Brandy hill quarry appendix 11- Air quality EIS response

Comments

Figure 6-2: Dust Deposition (Insoluble Solids) Results [Hanson, 2014]

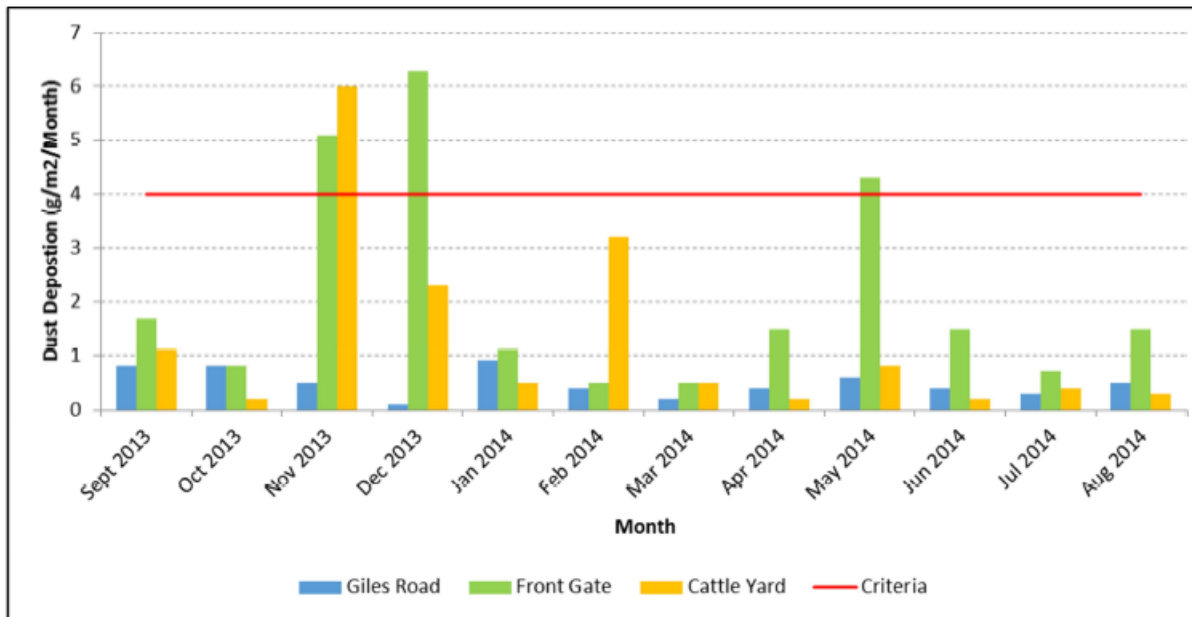
Comment: This data is not based on a calendar year like inputs into the TAPM-CALMET-CALPUFF models. The Air quality model is based on 2013 calendar year data. It is from Sept 2013 to August 2014. Every exceedance is blamed on bird droppings, no inorganic value is stated which would give a dust particulate value. There is no commentary on operational activities and weather conditions. Without these parameters and the fact that dust gauges are easily tampered with and provide a 30 day average result, the validity of the data is questionable.

Figure 7-1: Comparison of Patterson AWS Wind roses and TAPM Wind roses

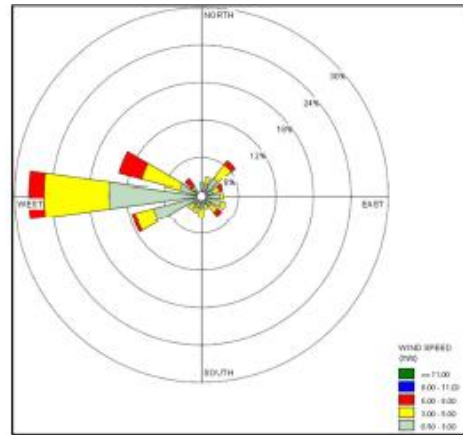
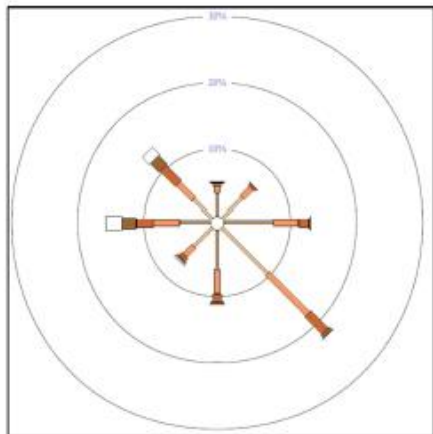
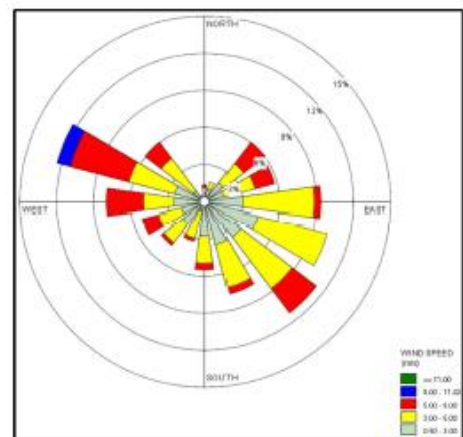
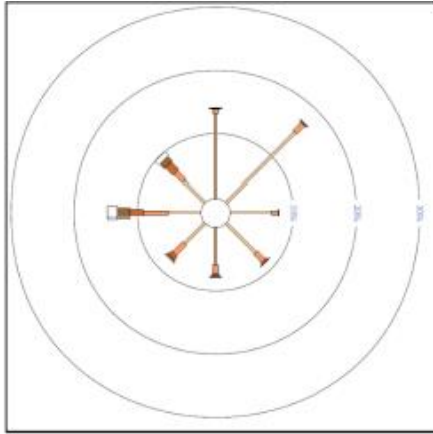
Comment: Why are these wind roses considered valid when the overall location does not align with the AWS location (Tocal). The wind rose could also not be extracted from the calmet model.

Comment: are these seasonal or annual wind roses no explanation given.
